Consultation Response from KC, Conservation and Design
2021/90033 83, Imperial Road, Edgerton, Huddersfield, HD1 4PG
Erection of two storey side extension
Date Responded: 29/01/21 Responding Officer: Craig McHugh Responding Ref: Edgerton

02b GF Proposed
1 : 100

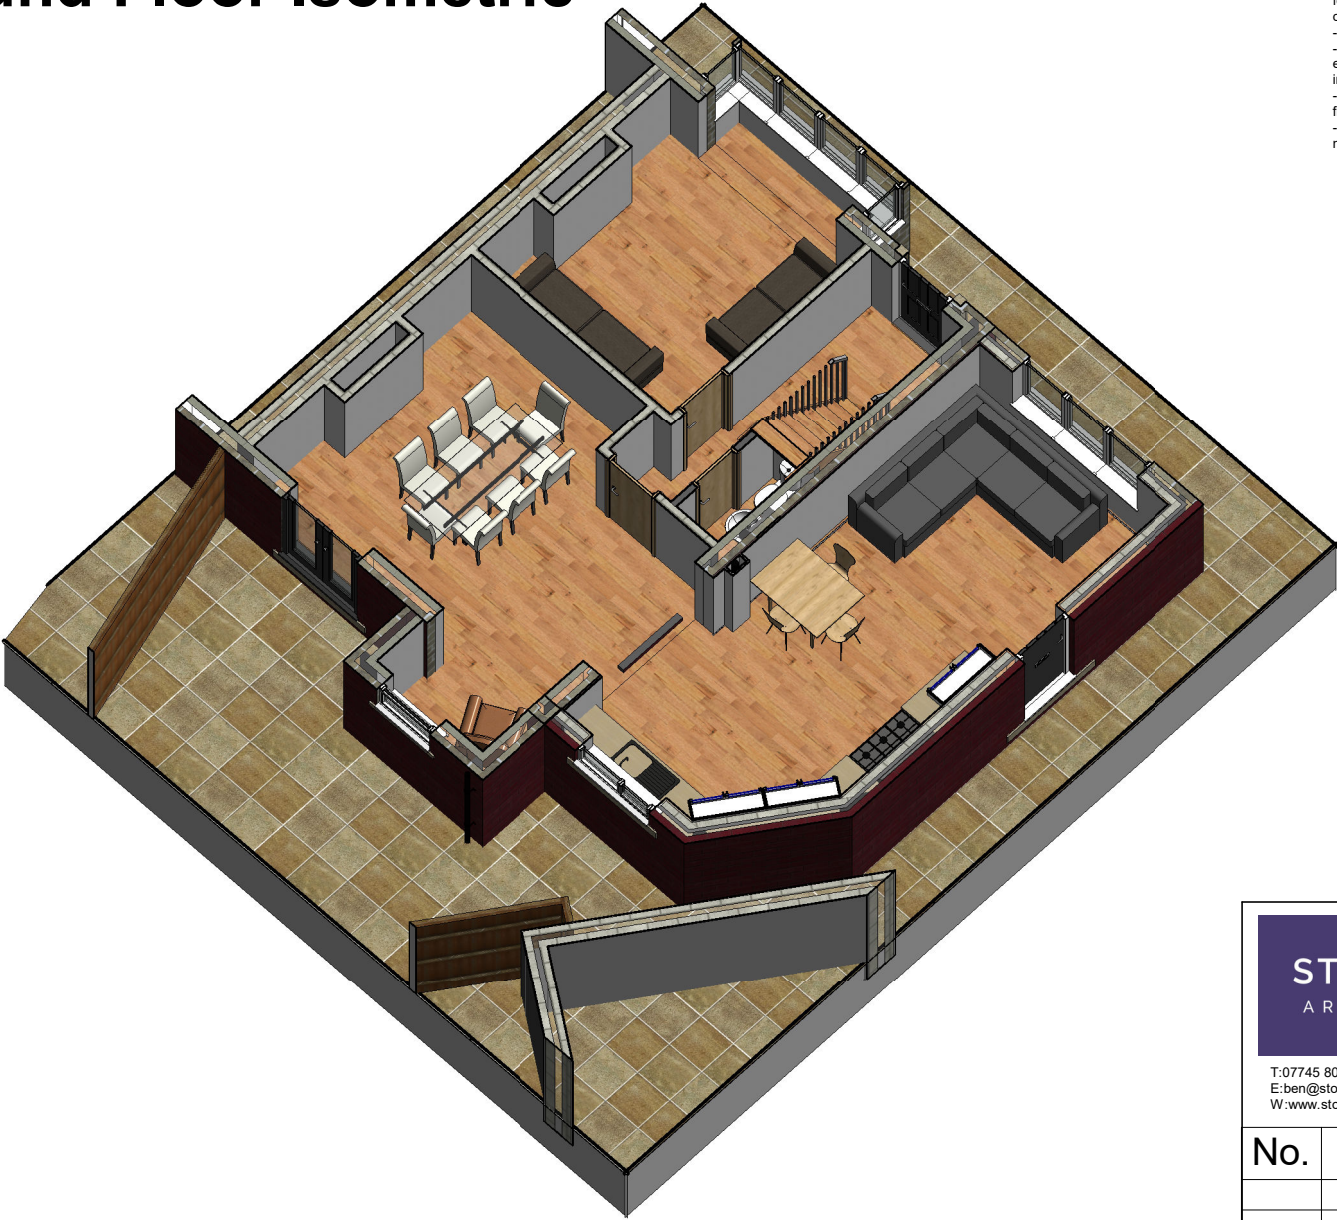
With regards to the design of the proposed extension, a similar extension has been made to no.81, however in that instance the extension was only one room deep and adjacent to a building of the same materials and design. In this instance the extension would be the full depth of the building, result a minimal separation between the two neighbouring buildings at the rear. This would create a terracing effect when viewed from the street and have an unacceptable visual impact creating a clash of styles and materials. To minimise this terracing effect and visual impact, the depth of the extension should be reduced to that at no.81, that is approximately 5.8m deep.

Conservation and Design have no concerns about the proposed development on heritage grounds. However, the scale of the extension should be reduced to improve the design of the development so that it respects the character of the townscape and minimises the visual impact on the adjacent building.
